National Infrastructure
Planning
Temple Quay House
2 The Square
Bristol, BS1 6PN

Our Ref: EN010148

Date: 15 August 2025

Application by RWE Renewables UK Solar and Storage Limited for an order granting development consent for the Tween Bridge Solar Farm project.

Figure 6.3: Screened Zone of Theoretical Visibility with Viewpoints and Photomontage Locations

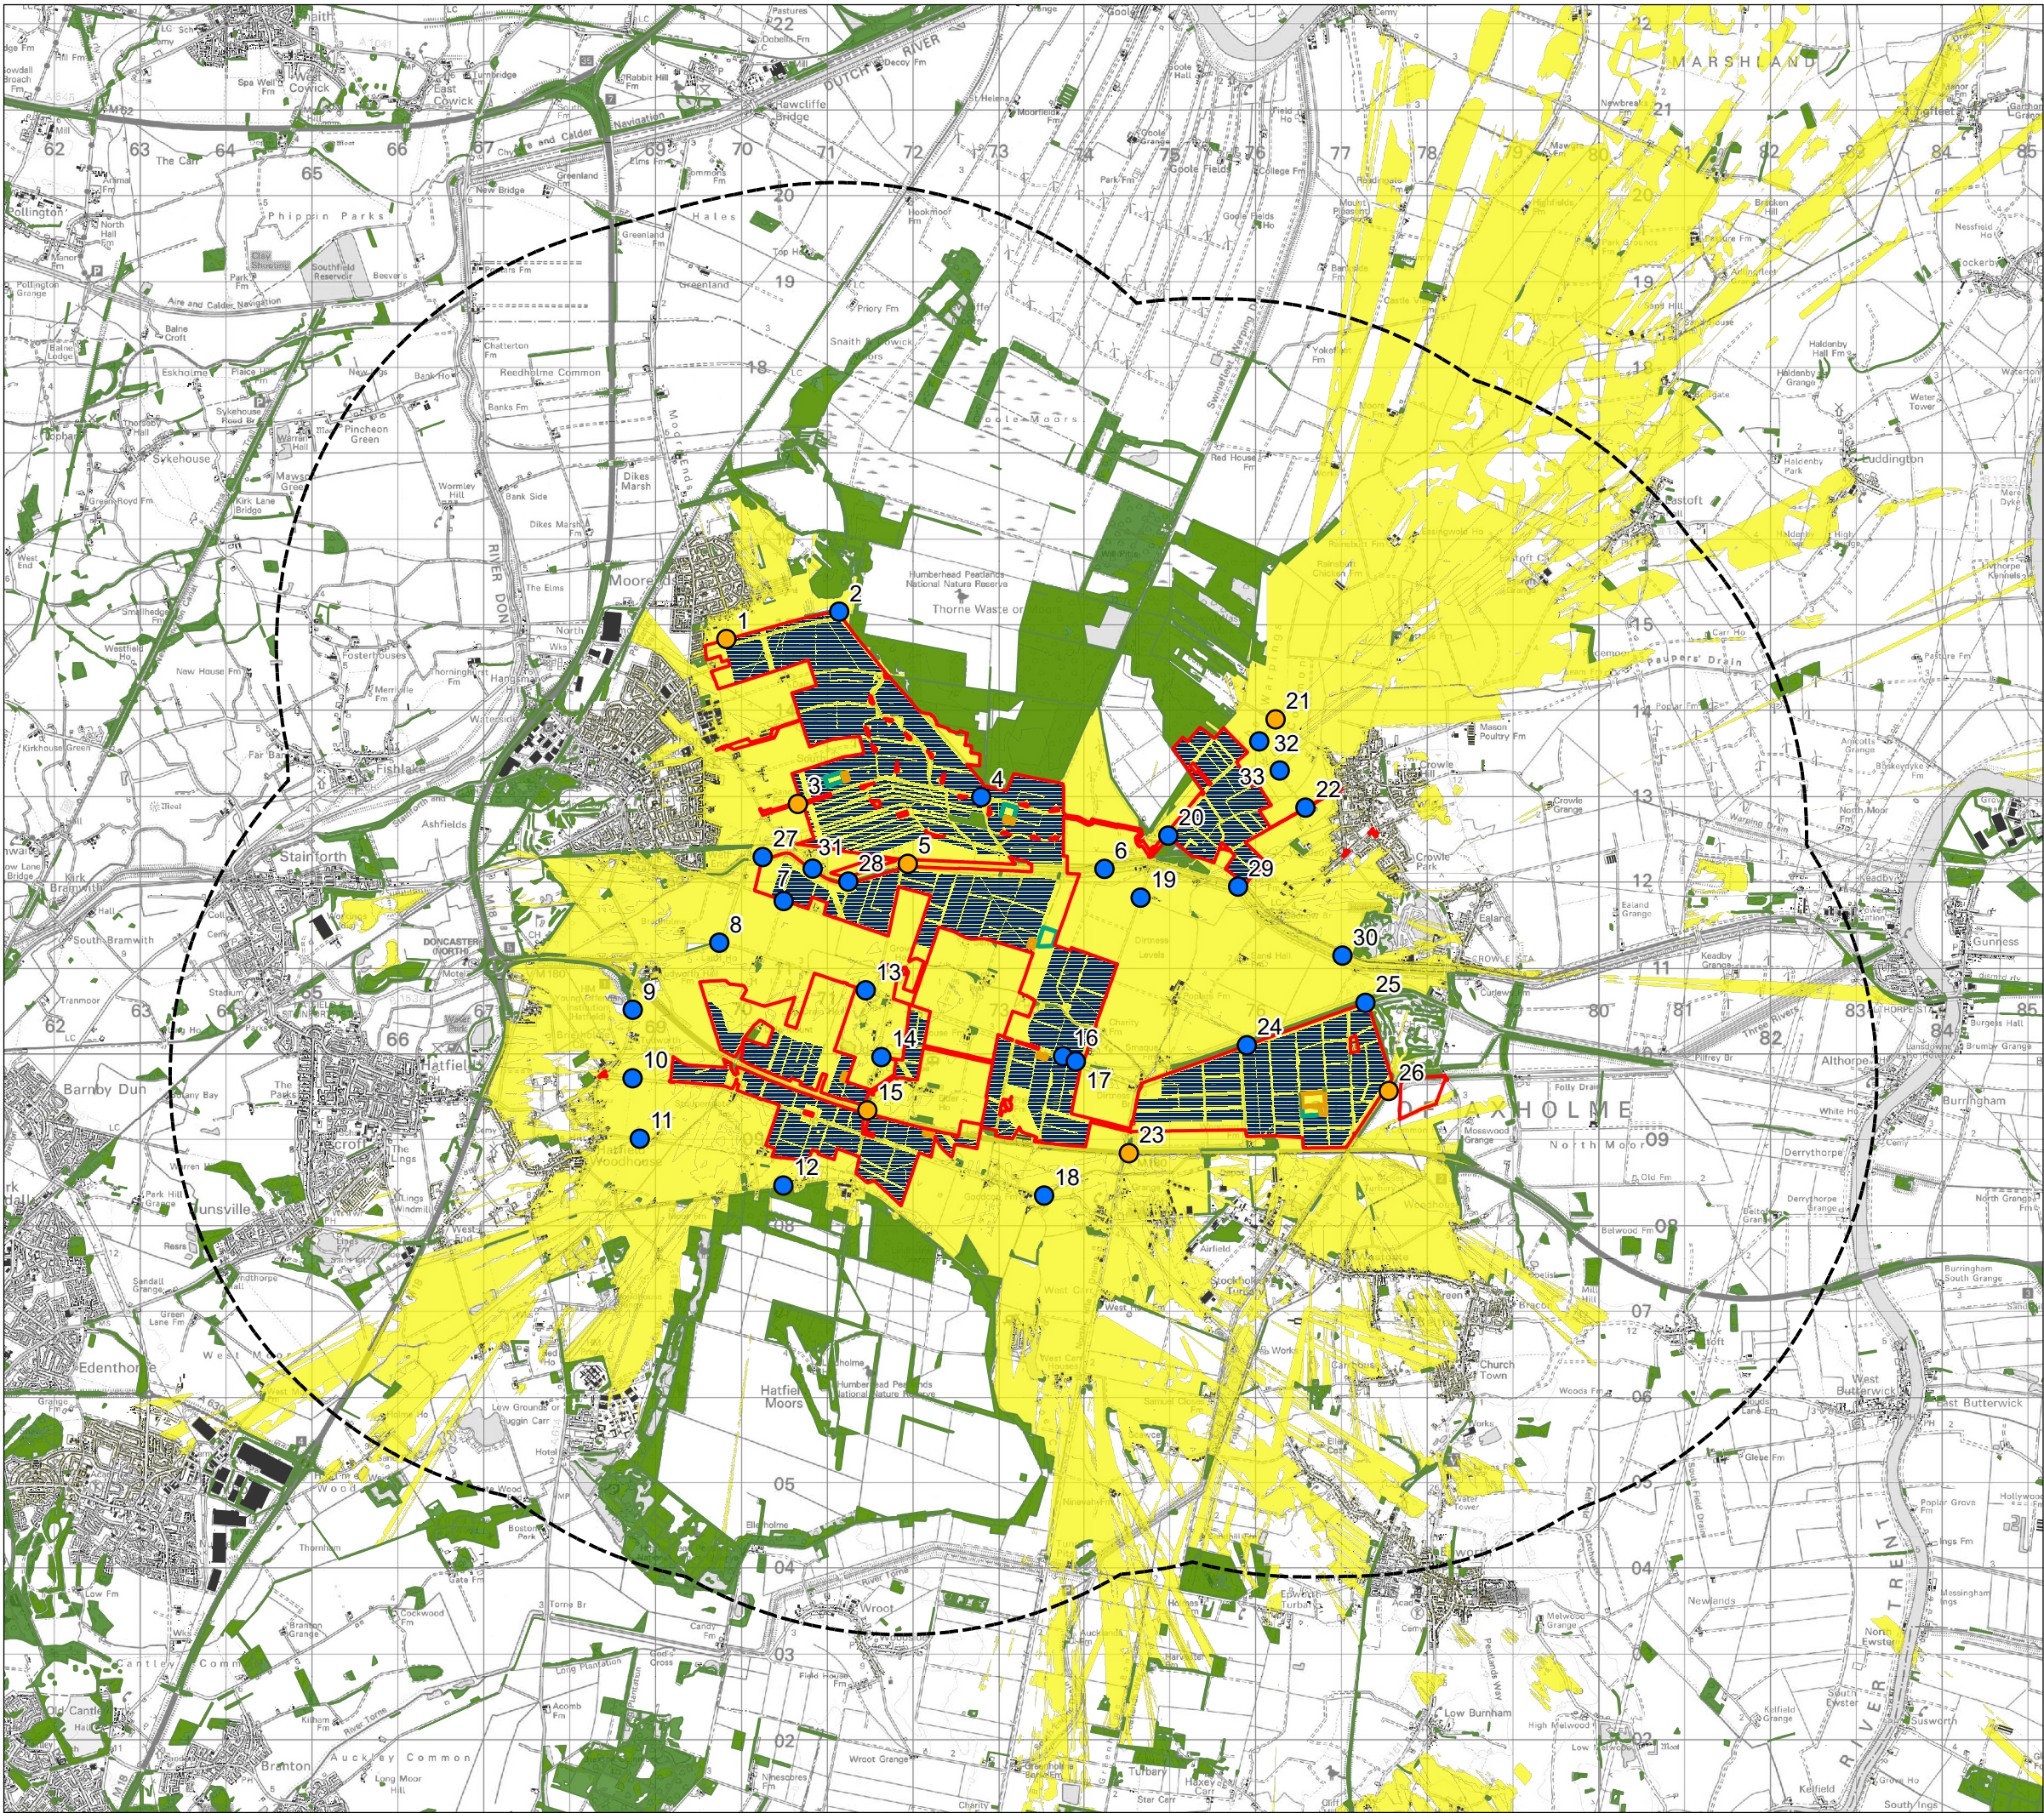
- Doc 6.4.1.3 ES Figure 1.3 parcel plan
- Doc 6.4.2.1 ES Figure 2.1 construction layout
- Doc 6.4.2.2 ES Figure 2.2 operational layout
- Doc 6.4.2.3 ES Figure 2.3 height parameters
- Doc 6.4.2.4 ES Figure 2.4 Horizontal Directional Drilling (HDD) crossing – this does not appear to include any HDD crossings in Parcel F, despite Figure 6.4.2.5 (Culvert Crossings) showing no culvert crossings in Parcel F.
- Doc 6.4.2.5 ES Figure 2.5 culverts crossing
- Doc 6.4.6.1 ES Figure 6.1 site context
- Doc 6.4.6.3 ES Figure 6.3 Zone of Theoretical Visibility (ZTV)
- Doc 6.4.6.6 ES Figure 6.6 ZTV

An example of how the 400kv cable route (Parcel F) has not been considered sufficiently includes the lack of viewpoints in this area, as shown on ES Figure 6.4.6.3. That is despite ES Figure 6.4.3.1 showing the Peatlands Way Long Distance Walk and public right of way (PRoW) bisecting this part of the Order Limits. It is not clear whether temporary closure of this PRoW has been considered.

The applicant is advised to take into account the absence of the requisite detail in the ES chapters given the omissions in the appendices and figures identified above to ensure that all assessments undertaken in the ES fully reflect all potential receptors or the zone of influence for the proposed development. The applicant is advised that this should be addressed and updates be made, as necessary, to the assessments within the ES and any relevant application documents.
